Department of Transportation

December 14, 2021

SH 24G/94A
El Paso County

RE: Crossroads at Meadowbrook Filing No1 - SF2129

EXISTING DRAINAGE MAP
CROSSROADS MIXED USE
JOB NO. 18-003
DATE PREPARED: FEBRUARY 23, 2021
DATE REVISED:

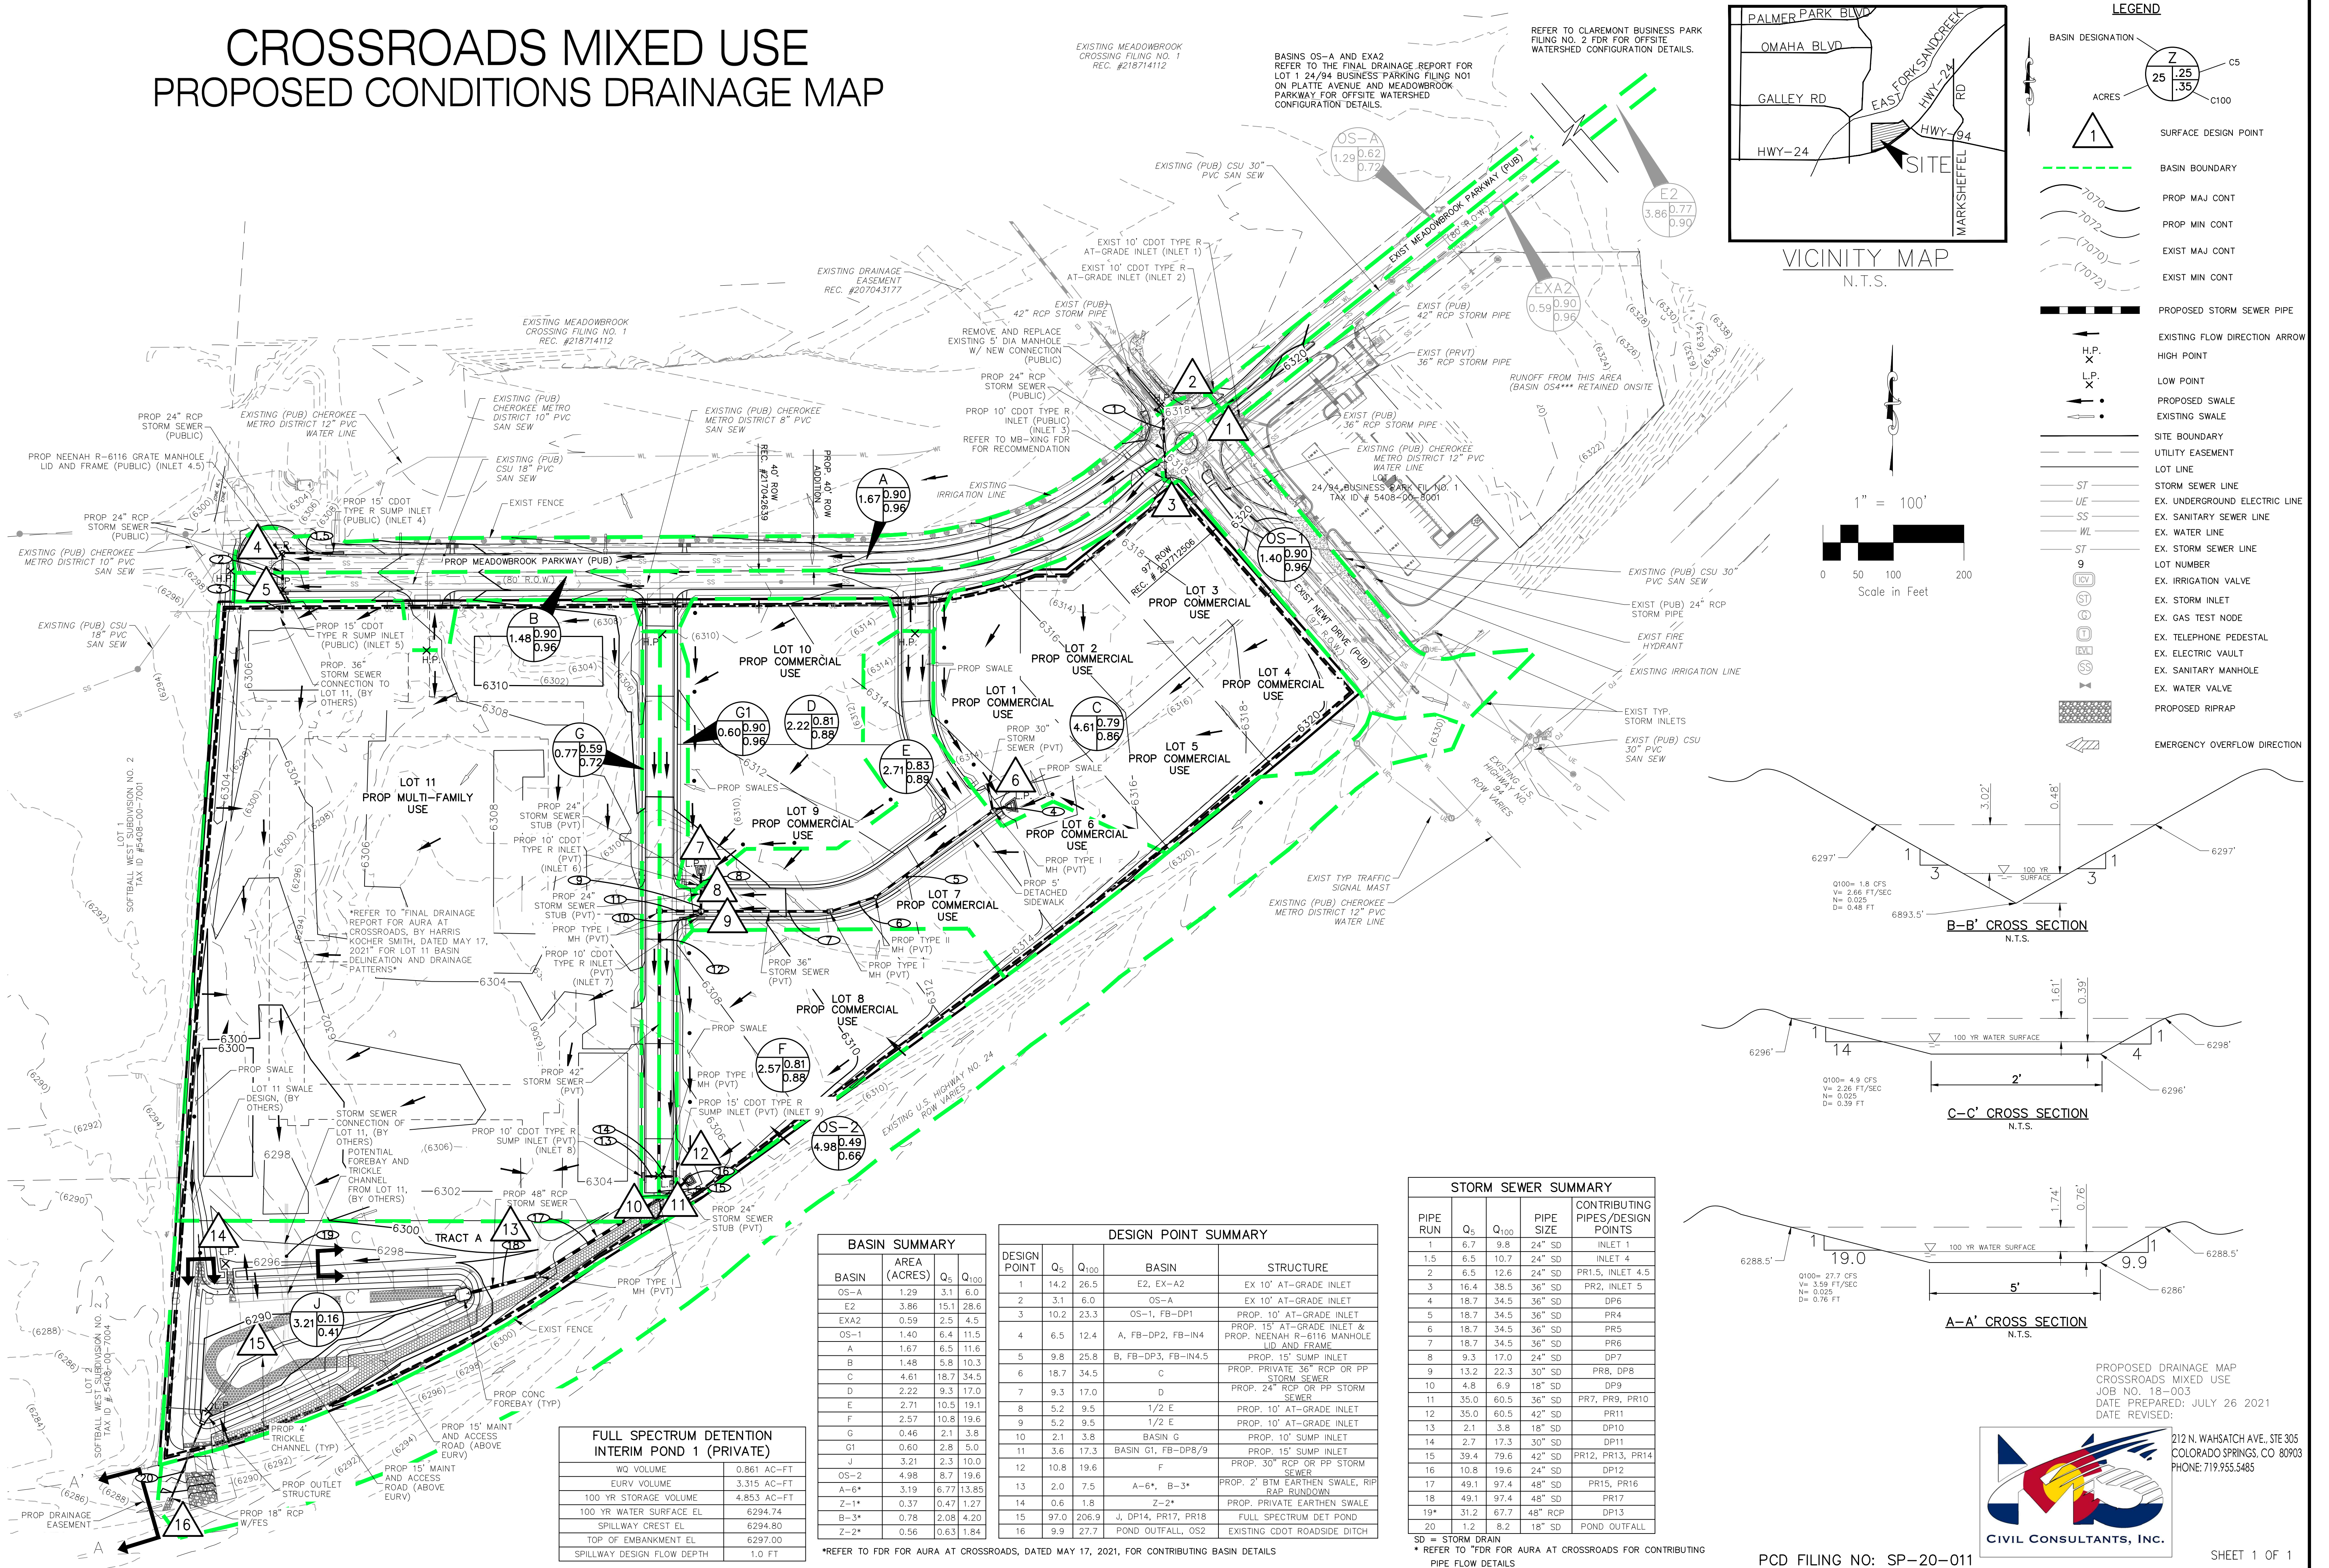
- **March 24, 2021 comments:** Existing conditions topo map shows that existing flow at the SW corner sheet flows to the west and that flow does not enter the existing roadside swale. The proposed detention pond outlet concentrates and directs this flow to the roadside swale, which will cause erosion. Please coordinate with CDOT Hydraulics Engineer to design suitable outlet protection.

FINAL PLAT
CROSSROADS MIXED USE
FILING NO. 1
JOB NO. 18-003
DATE PREPARED: 06/23/2021
DATE REVISED: 06/06/2022

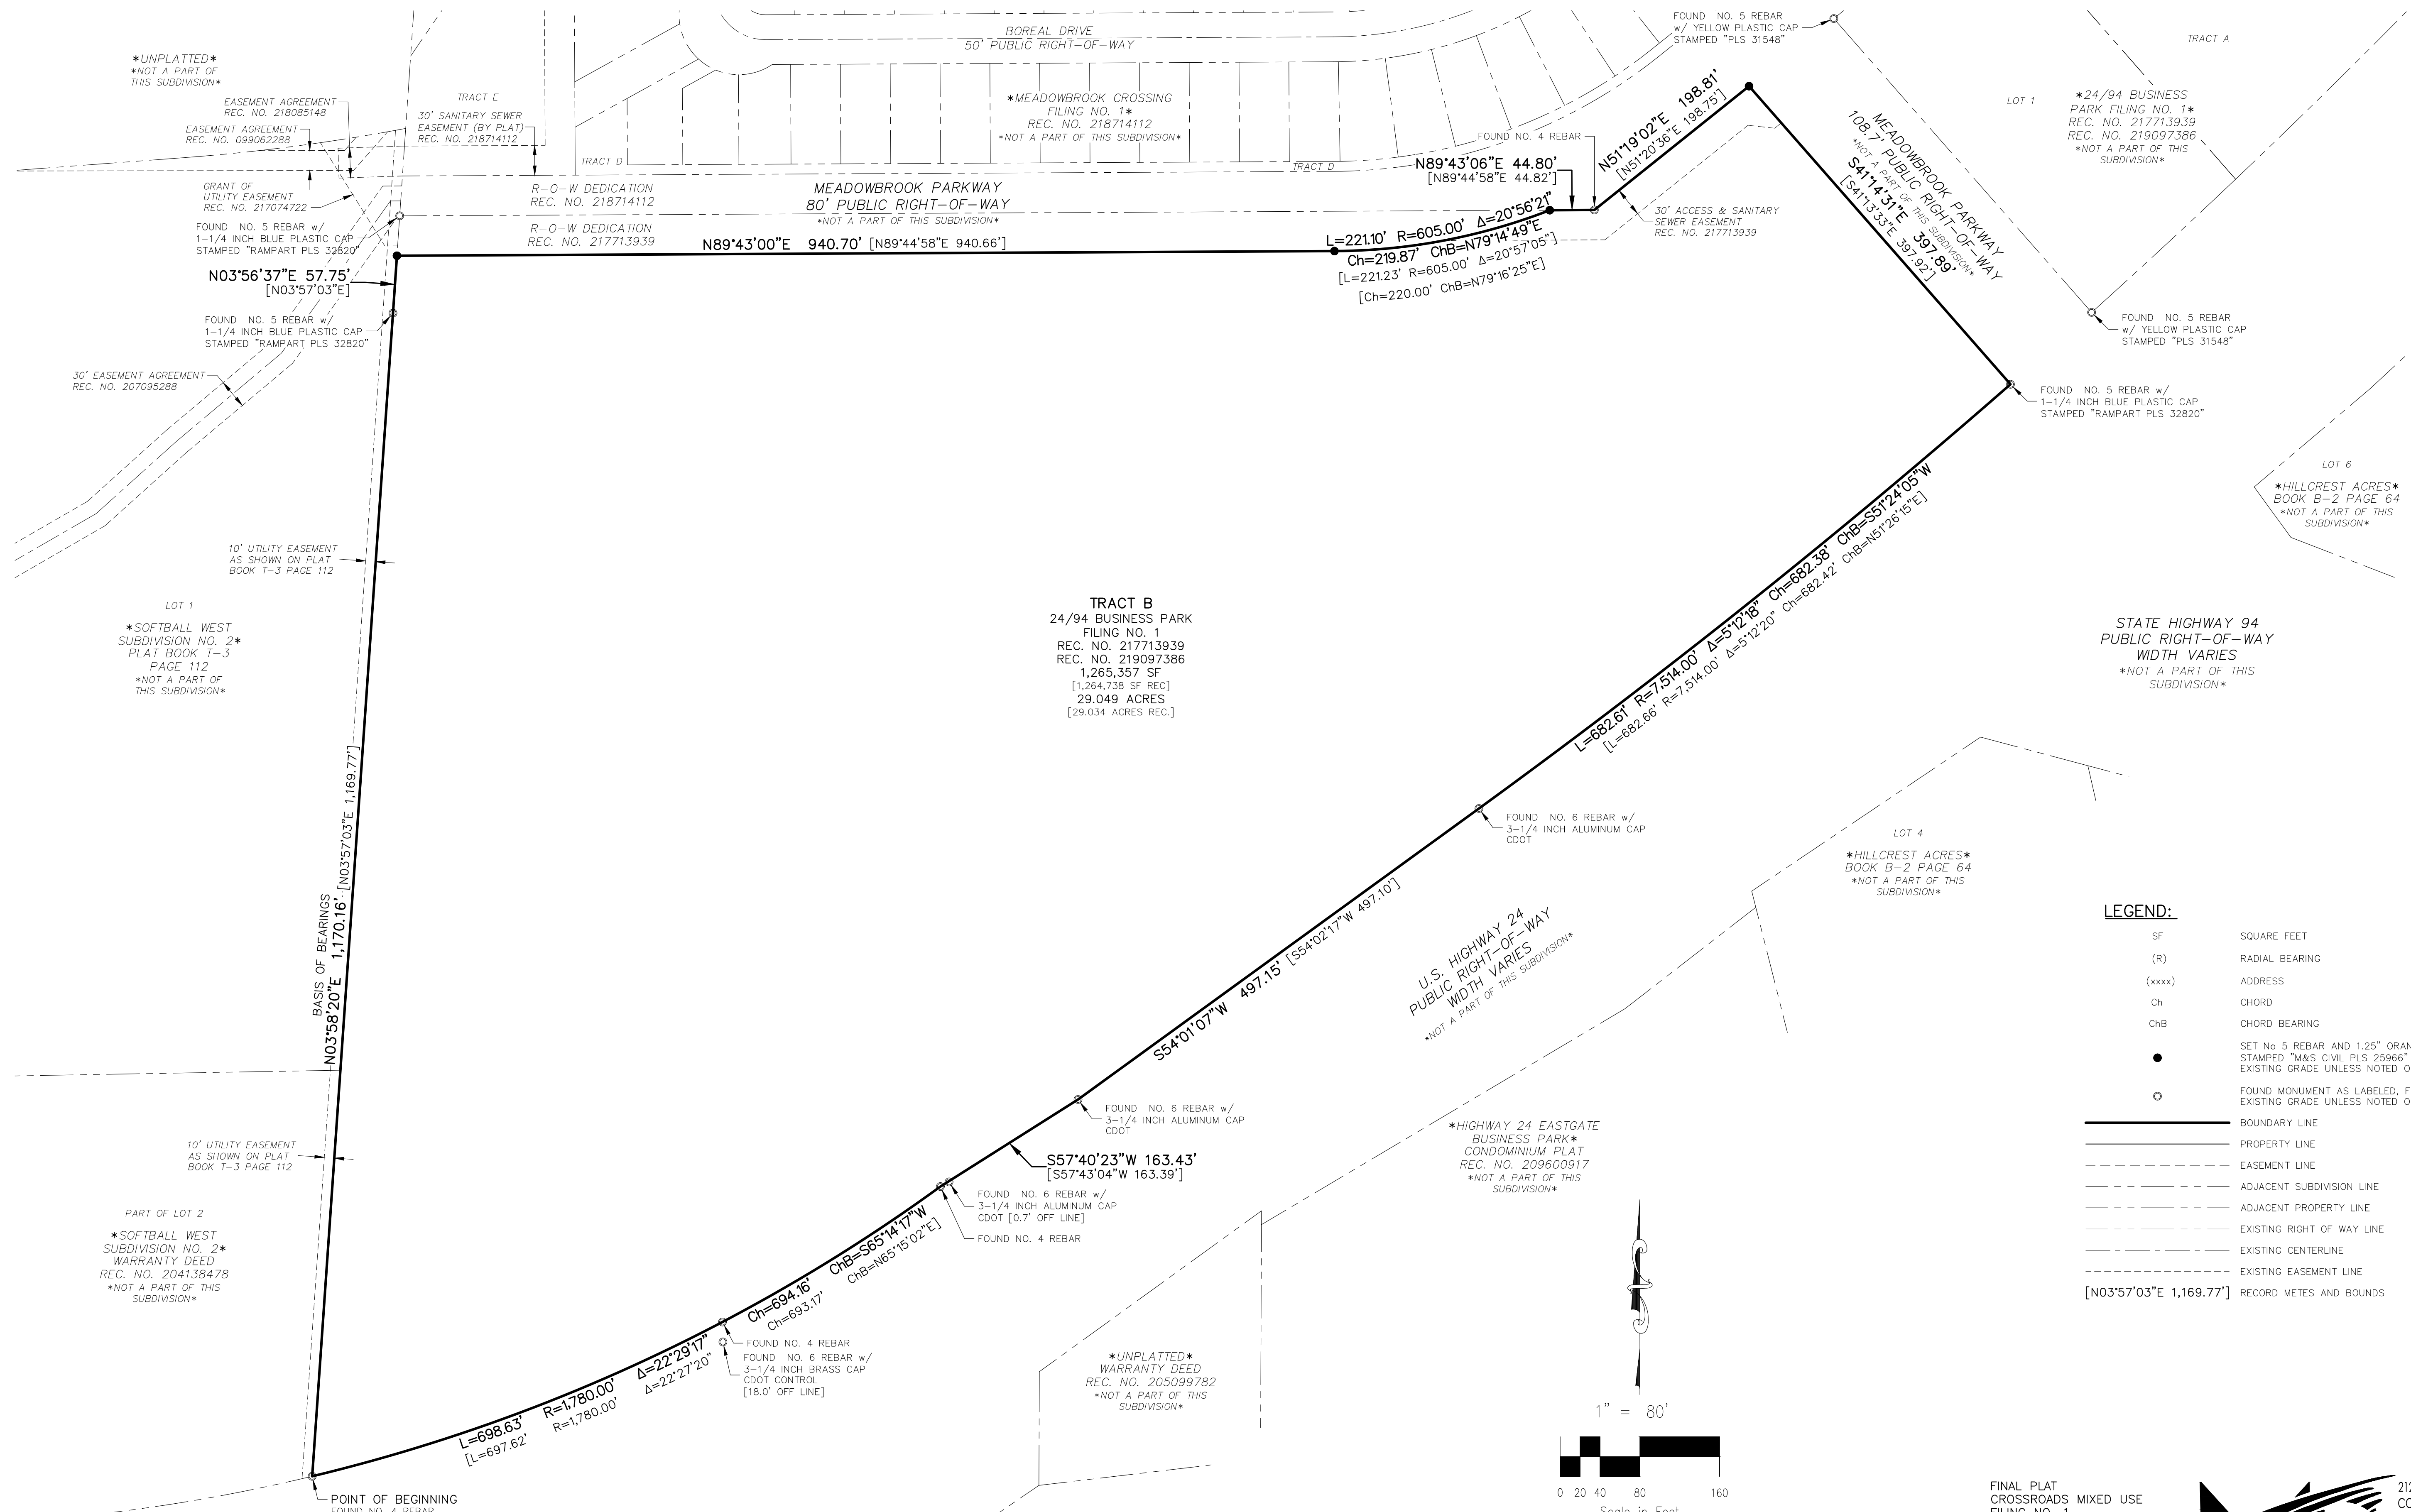
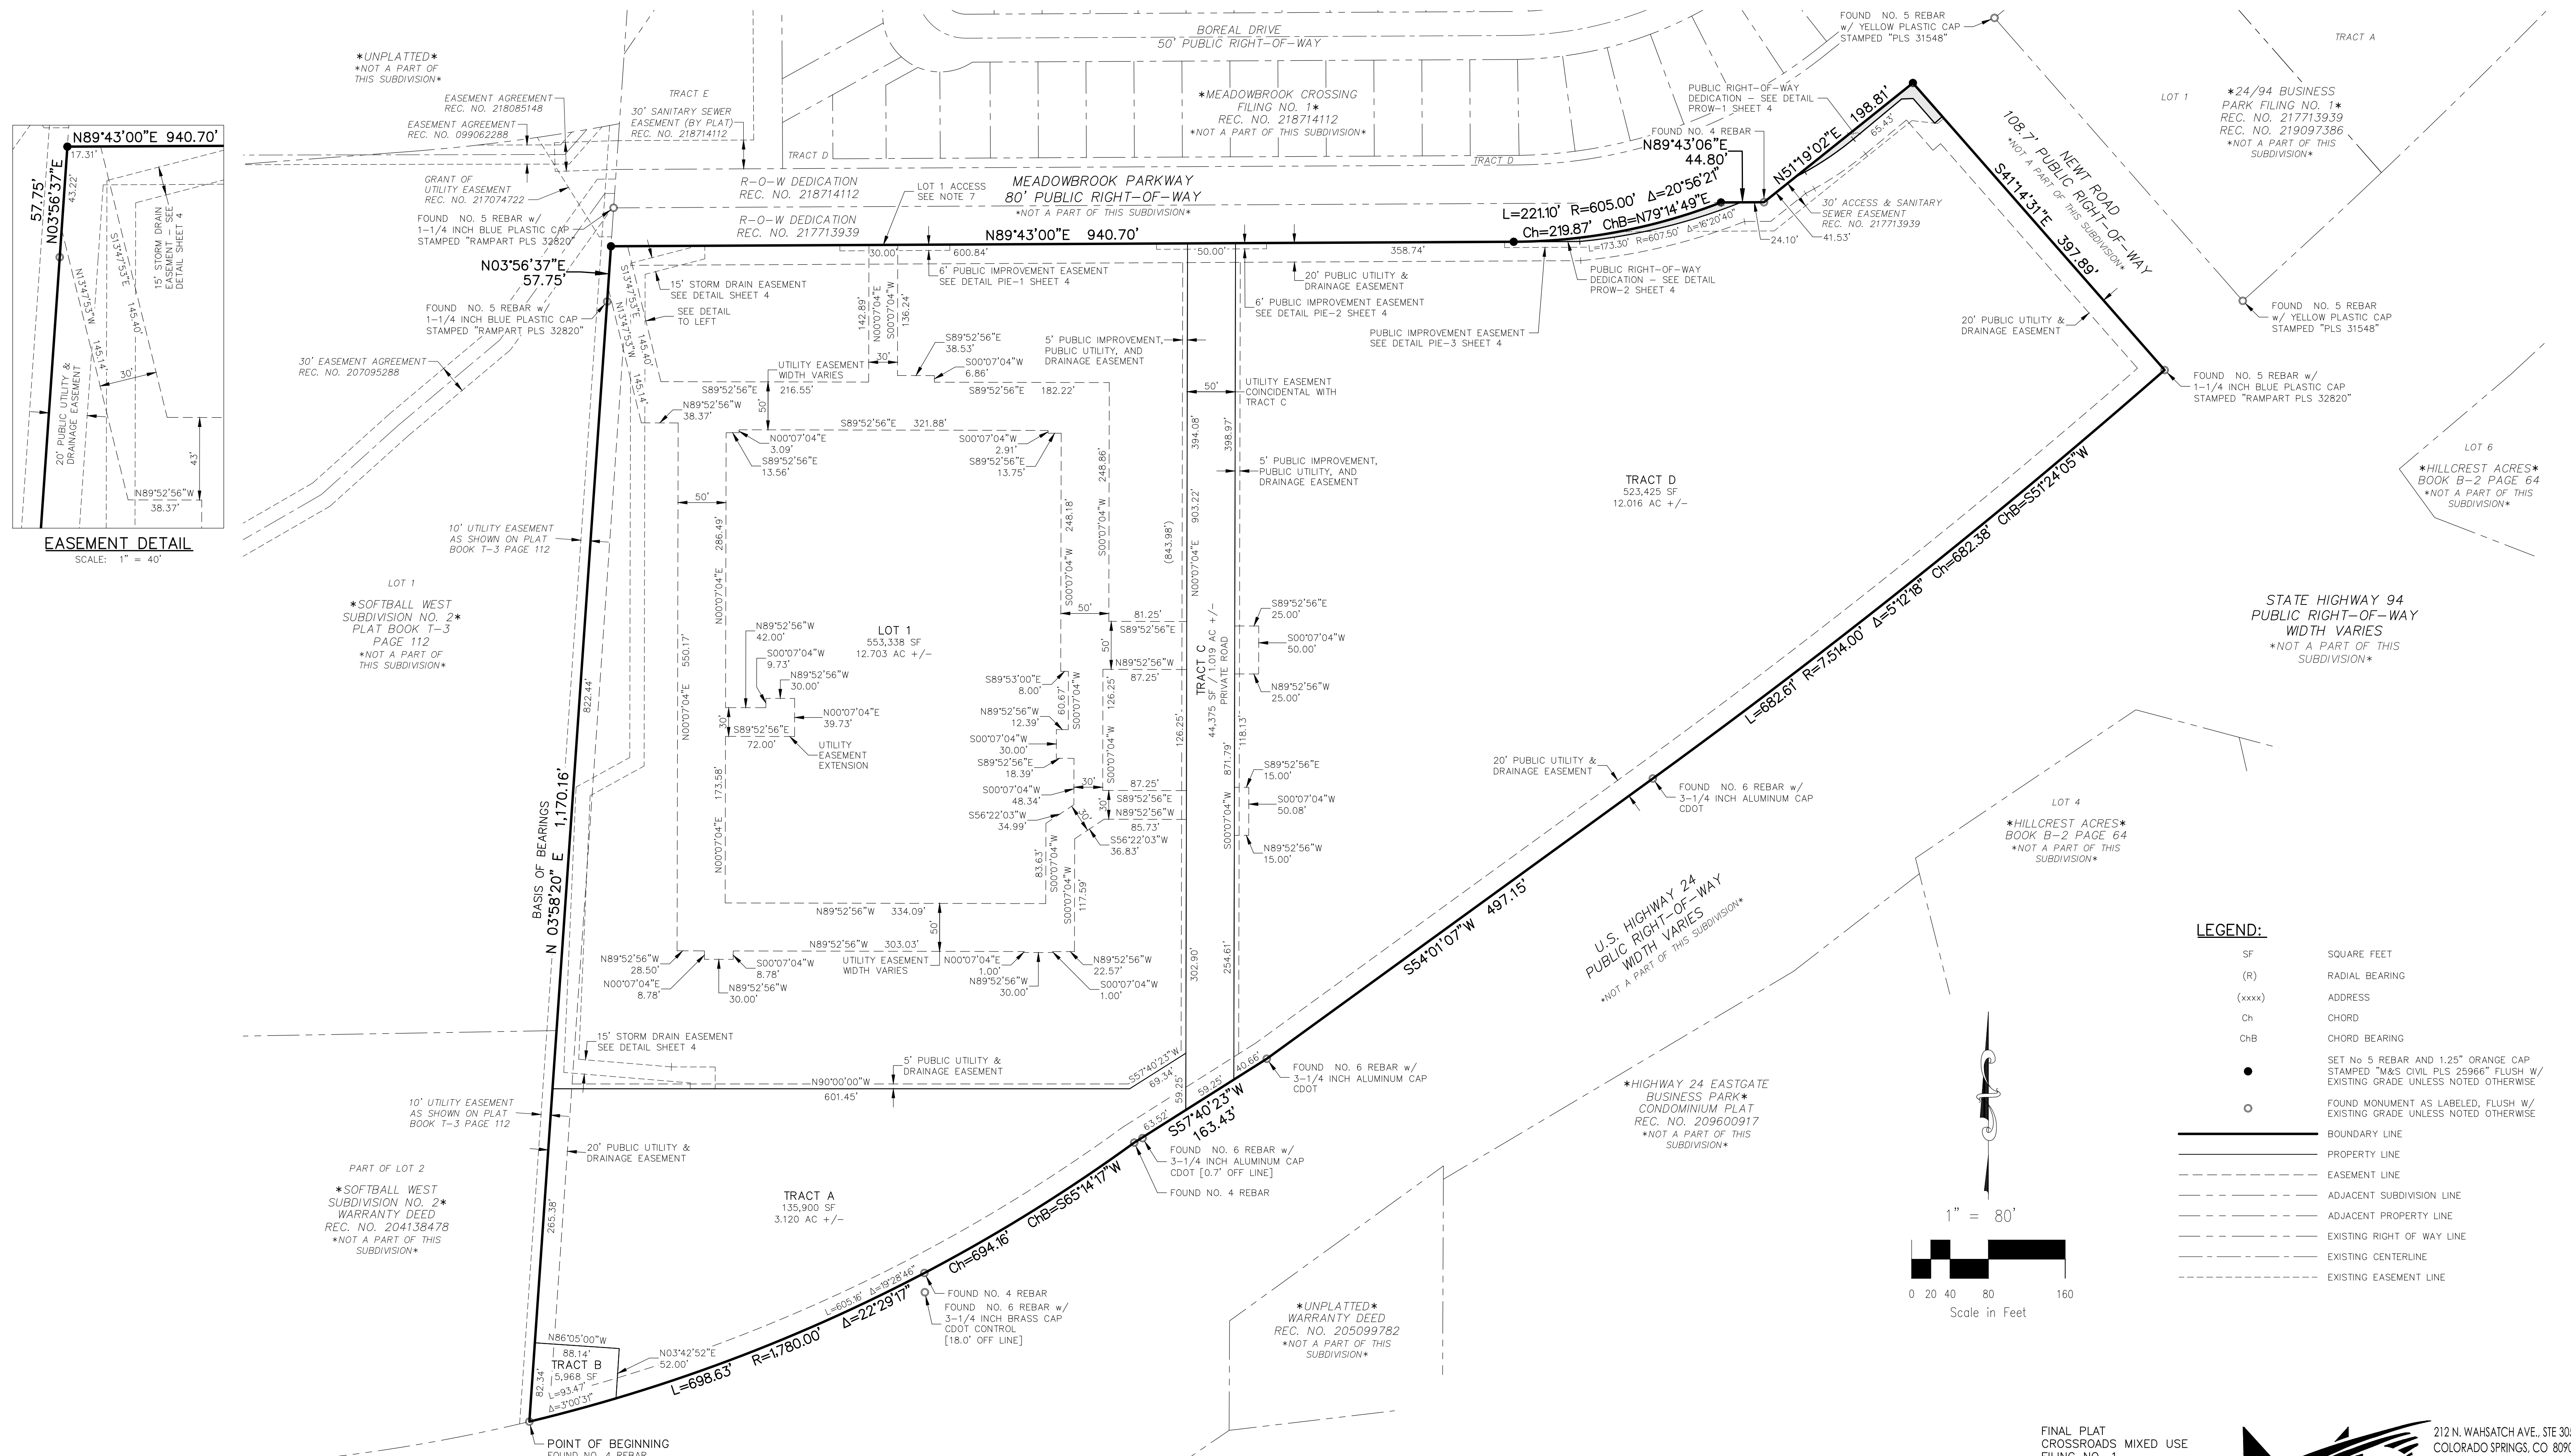
- **As has been previously stated the plan shall reserve public right-of way for the future interchange at US24 & 94. The plat, as submitted shows no reservation or ROW dedication.**
- CDOT is requesting ROW dedication along US24 south of the intersection of SH24 east and west side of the roadway and north of the intersection east and west side of the roadway for the footprint of the El Paso Counties PEL Study and for the expansion of US24 to include three thru lanes EB and one acceleration lane off of Newt.

- **The current Filing No. 1 Plat does not show dedication of ROW and will need to be revised and rereviewed.**
- The developer is required to apply for a new Colorado Department of Transportation Access Permit for the connection of Newt Dr. to SH24G. An Access Permit is required at the intersection location of (SH24 and Newt Drive). The change in land and access use rules apply as detailed in the State Highway Access Code 2002, Section 2.6. **This has not been done to date.**
